**SUBMISSION TO SSD10407
14 AND 16 KIORA CRESCENT, YENNORA SSD10407
STATE SIGNIFICANT DEVELOPMENT APPLICATION
YENNORA LIQUID WASTE TREATMENT PLANT**

Reference is made to the abovementioned State Significant Development Application (SSDA) (**SSD10407**) (the proposal), lodged with NSW Department of Planning, Infrastructure and Environment (DPIE) on 13 November 2020, which seeks development for the purpose of *the increase in the processing capacity of the existing Yennora Liquid Waste Treatment Plant to 110,000 tonnes per year*.

Figure 2.1. Swept paths for heavy vehicles accessing the site at 14- 16 Kiora Crescent, Yennora. NSW Surveys PTY LTD, 8/11/19.

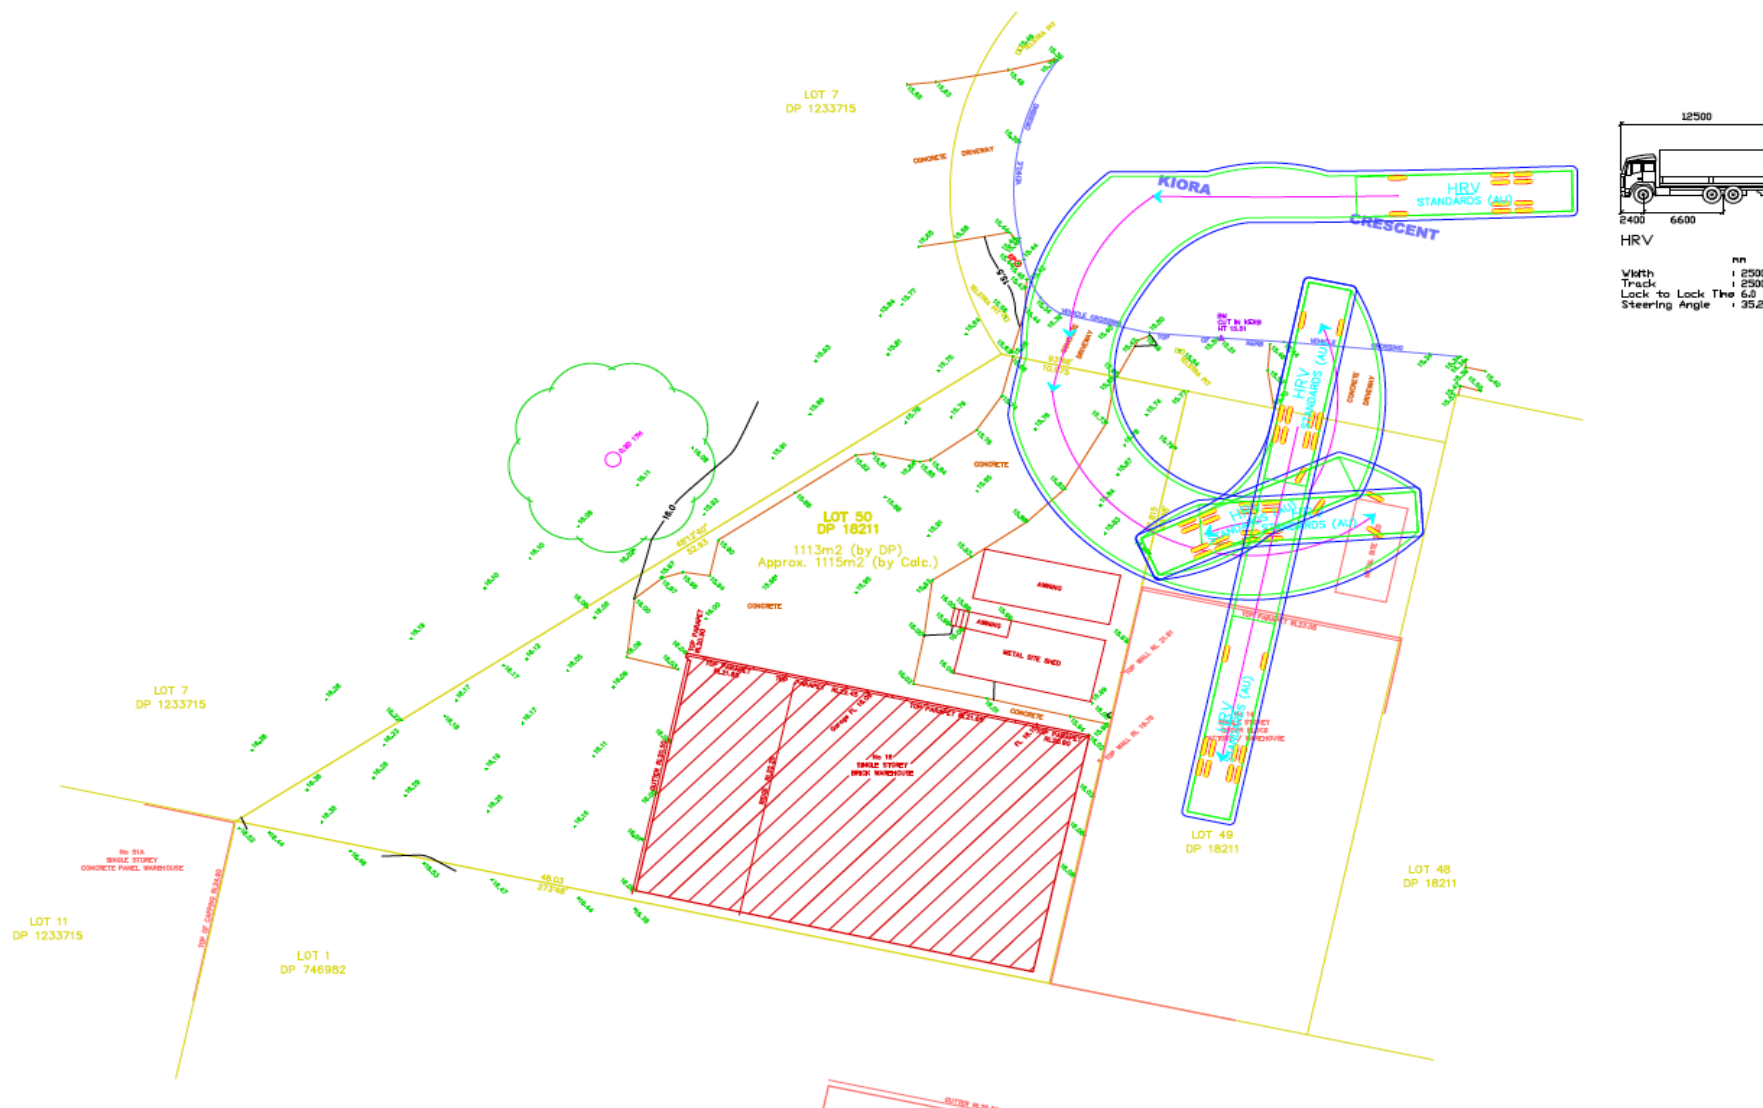
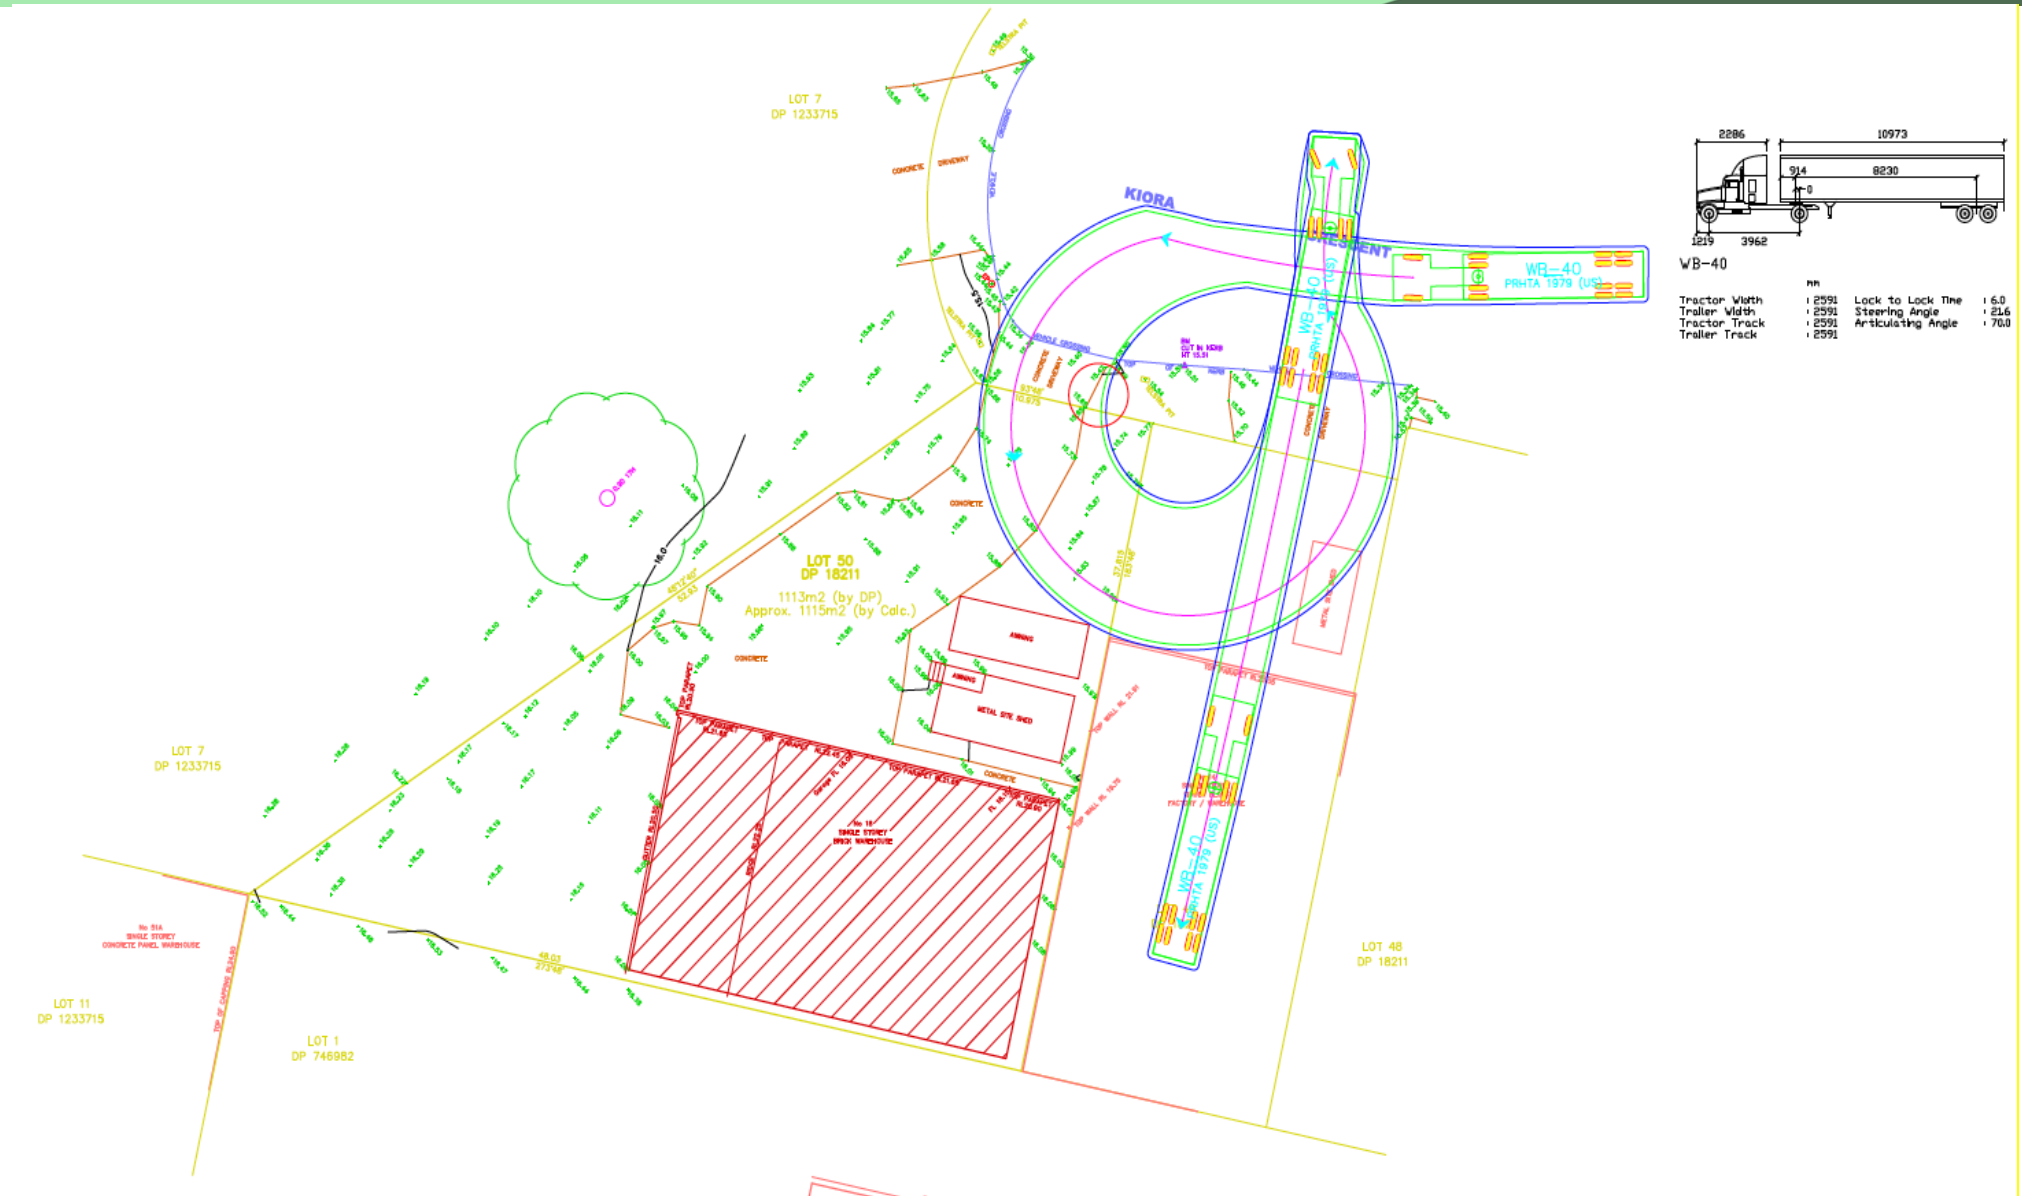
The SSD application has failed to address the cumulative impacts of the development in terms of considering other nearby transport and logistics business as well as the Site being located in a dead-end street. Furthermore, the provided sweep path analysis still shows that the turning path of trucks encroaching into Council footpath and nature strip which was a key concern of Council as part of initial consultation. In addition, the Council consultation comments from May 2020 specifically required that trucks are to complete no more than 3 movements to enter the waste dock. It is apparent from the submitted sweep paths that trucks will need to complete a minimum of 4 movements and will also cut across existing car parking spaces on the Site.

The car parking rates used by the consultant are also confusing as they seem to refer to factory rates but then utilises the warehouse rate in the calculation. Whilst the proposed development may meet the required rate of car parking spaces as per the Holroyd DCP, which is based solely on GFA, the application has failed to acknowledge the intensification of development on the Site. The existing parking on site, being seven (7) spaces, may be compliant with the DCP rate but we question the ability to have cars parked in these spaces given the expected maneuvers trucks will have to undertake to enter and exit the Site (as shown on the provided sweep paths).

The proposal will result in an increase in truck movements to 60 trucks per day, or 4 per hour, from currently 1 per hour, or 24 per day and relies on access from the driveway adjacent to 7 Kiara Crescent. Manoeuvrability of large rigid trucks onto the Site without disturbing neighbouring properties, blocking access driveways and impacting on-street carparking spaces appears to be almost impossible based on the

provided sweep paths. As such, further consideration needs to be given to the traffic control and the future 'controlled' access to the Site as it is surely almost impossible to not have trucks queuing along Kiara Crescent given only one unloading and parking area is provided on Site.
